## KITTITAS COUNTY COMMUNITY DEVELOPMENT SERVICES

**Subject: Palomino Fields Div 5 (LPF-19-00004) Final Long Plat – Staff Review, Request for Additional Information,**

PALOMINO FIELDS PLAT - DIVISION V

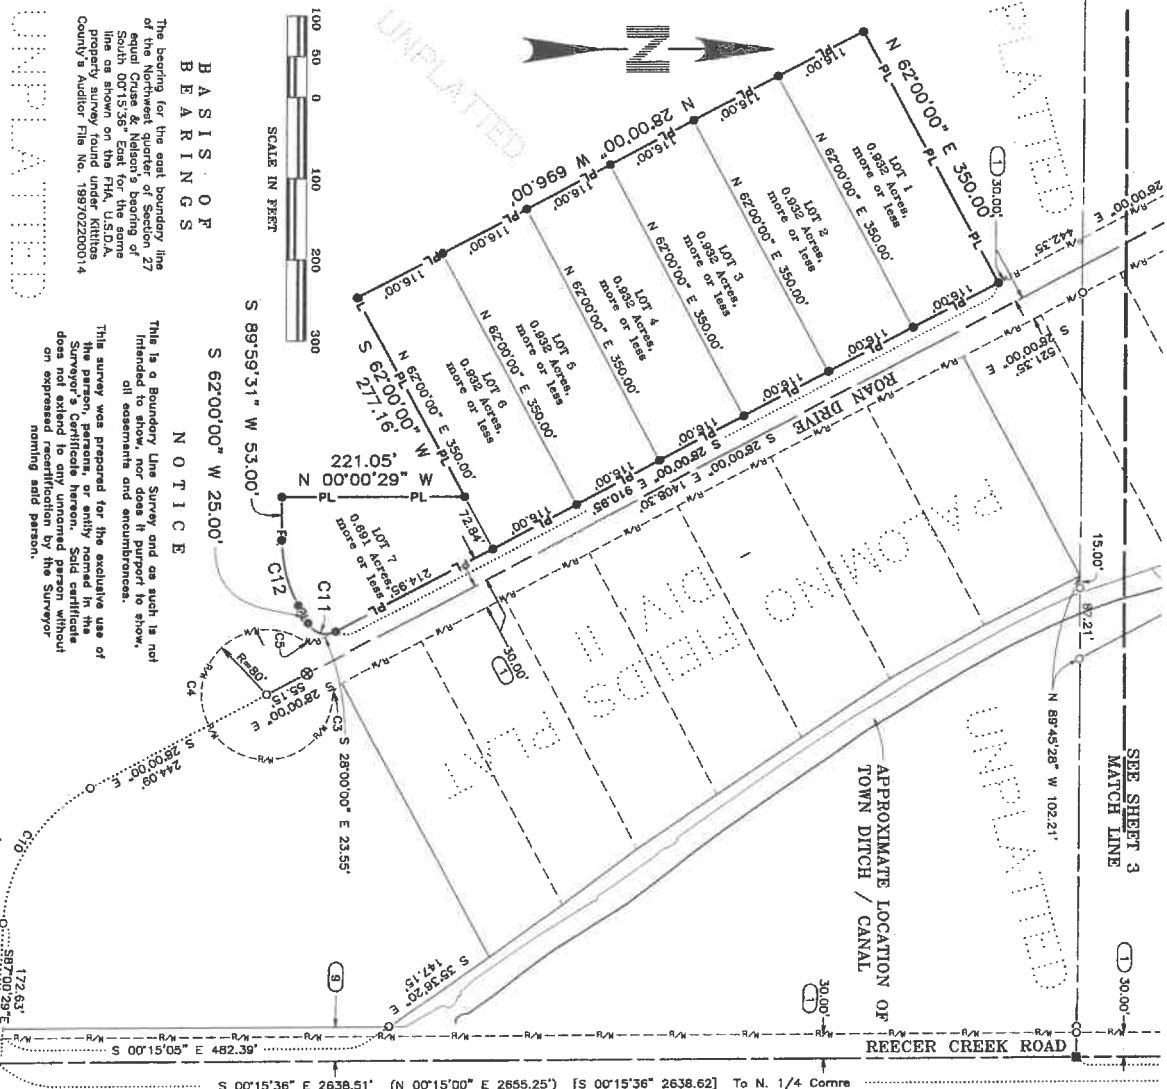
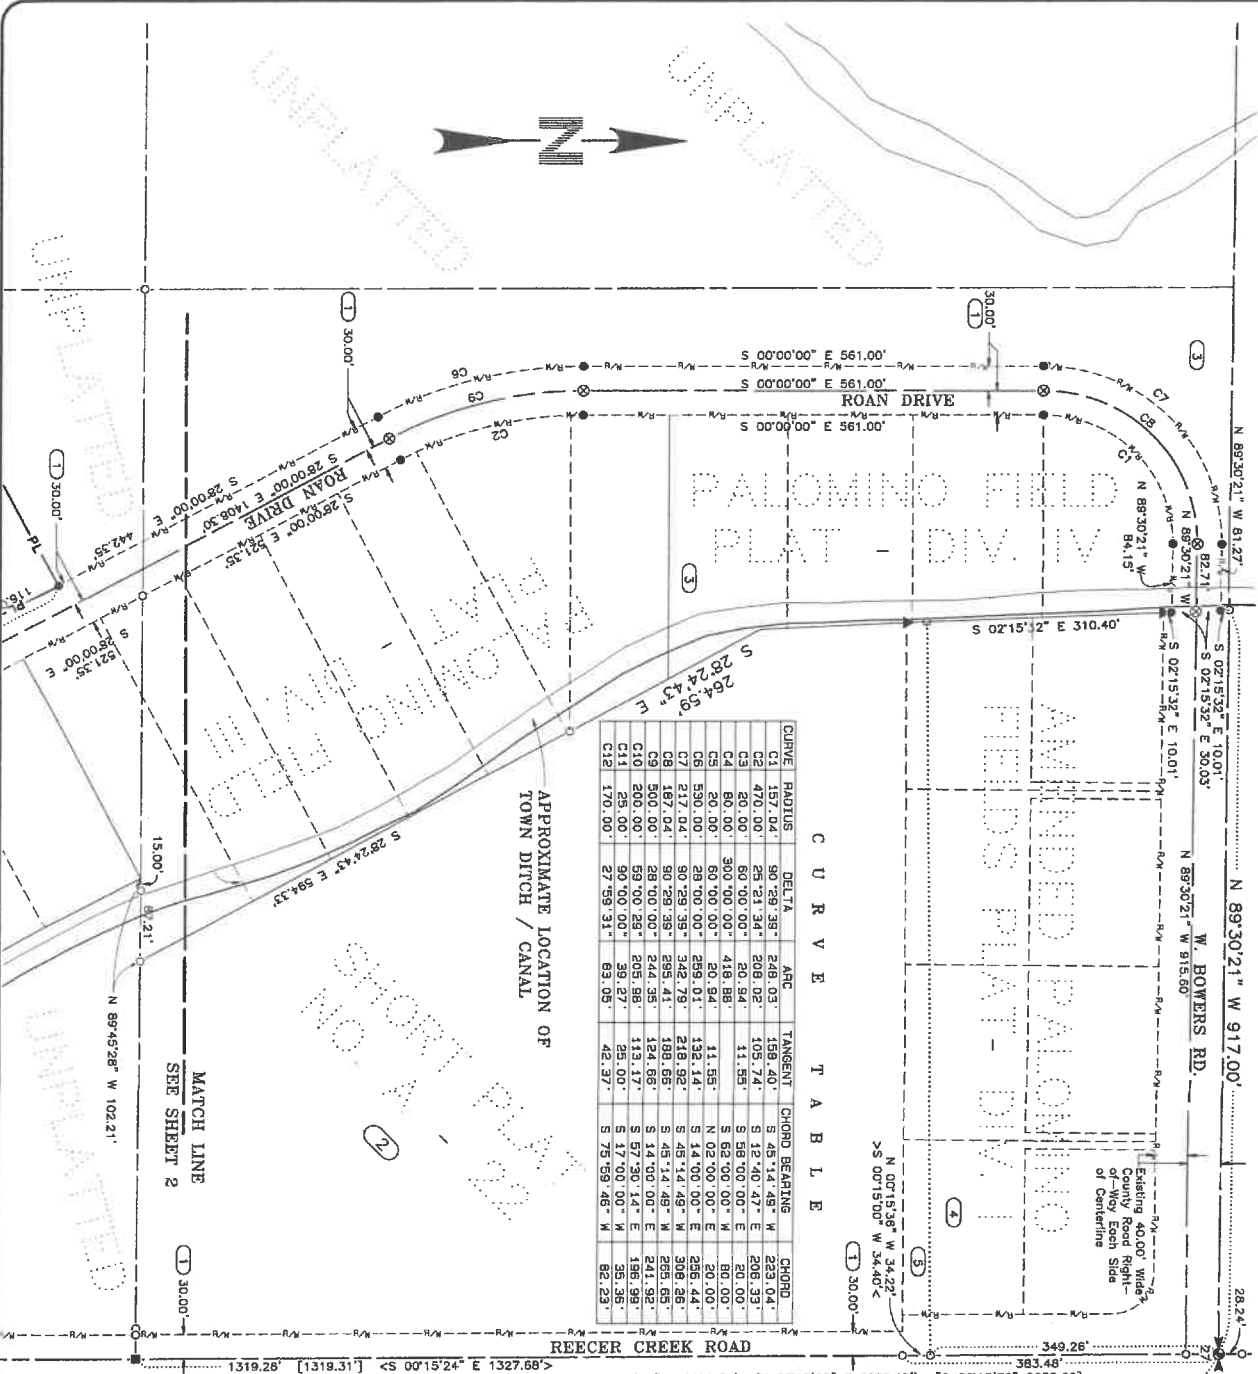
- The file number, "LPF-19-00004" and "LP-07-00031" should be represented on the face of the plat.
